From: Laura Gibbons
Sent: 22 January 2019 14:02
To: Planning.Responses
Cc: Anita Gardner
Subject: RE: Planning Consultation on EP/184/18/DOC

Engineers Comments Regarding Condition 9 and 10

Registered: 18-DEC-18
Site Address: Tudor Lodge 125A Sea Road East Preston BN16 1NX

Description of Works: Approval of details reserved by condition imposed under ref
EP/136/18/PL relating to Condition No 9 drainage scheme &
Condition No 10 surface water drainage.

Status : APPROVAL	
Scale: as noted @ A1	Date: MAY.2018
Drawn: MA	Engineer: VM
Checked: DL	Revision
Drawing No. L2340-C-52-750	04

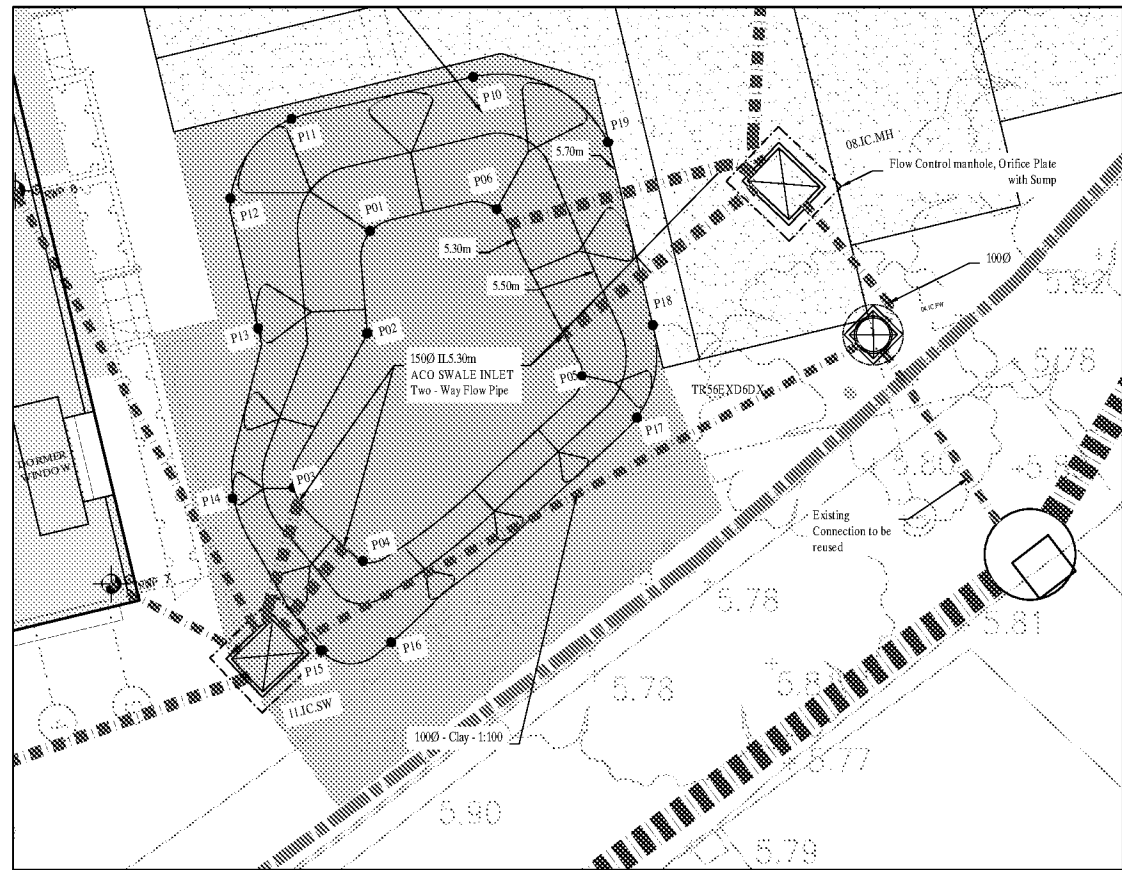
1. The proposals are to discharge to a foul sewer, not a combined sewer as stated. No evidence has been submitted that demonstrates that Southern Water have agreed that the proposed discharge rates are acceptable, i.e. that there is adequate capacity.

2. The attenuation pond is proposed to be unlined, can the applicant please confirm winter groundwater levels. It must be demonstrated that the pond and foul sewer will not be inundated by groundwater.

3. Proposals include two hydrobrake control chambers, both of these have discharge rates less than 2l/s. This is unacceptable. As previously requested only one control chamber should be provided. This is to reduce the risk of blockage.

4. Our belief is that to achieve this reduction to one hydrobrake an online attenuation pond will be required.
5. Calculations need to be provided which demonstrate that the surface water drainage design is adequate for all storm durations between 15 minutes and 24 hours.

6. Evidence has been submitted that demonstrates that infiltration at the site is not viable (infiltration rates less than $\times 10^{-6} \text{ ms}^{-1}$). As a result it has been proven by the applicant that informal permeable paving will not work. Therefore, we must see formal drainage provision for this area.

7. It should also be noted that the proposals for an informal permeable driveway are inadequate as no geotextiles are provided.
